**WEST SUSSEX COUNTY COUNCIL
INFRASTRUCTURE CONSULTATION**

**SUBJECT: R/49/09/ -House & detached garage (Amendment t previously approved
R/271/08)**

8, Bushby Avenue, Rustington, West Sussex

BLOCK PLAN Scale 1:500

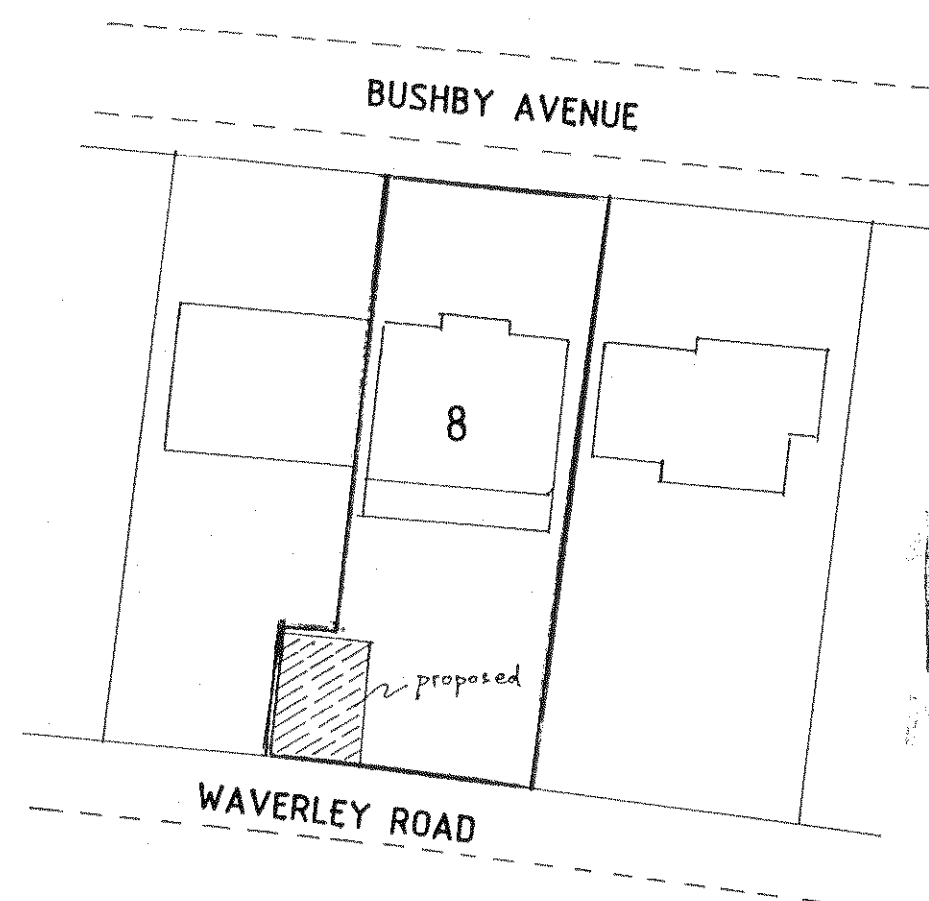
The proposal is for a house and detached garage with access onto Waverley Road via a new access point. The particular part of Waverly Road that the property will access is not maintained by WSCC. The proposed car parking is in accordance with the WSCC Maximum Standards and no concerns would be raised regarding that proposed. Cycle parking should be included however; this should be secure, covered and be capable of holding at least one cycle per bedroom of the new property.

From an inspection of the plans alone, there is no apparent visibility issue at the point of access onto Waverly Road. The most recently available verified accident records reveal there have been no personal injury accidents in the vicinity of the existing point of access, indicating a low risk of highway safety issues with this proposal.

No dwelling, hereby approved, shall be occupied until covered secure cycle parking spaces have been provided in accordance with a detailed construction plan to be submitted to and approved by the planning authority.
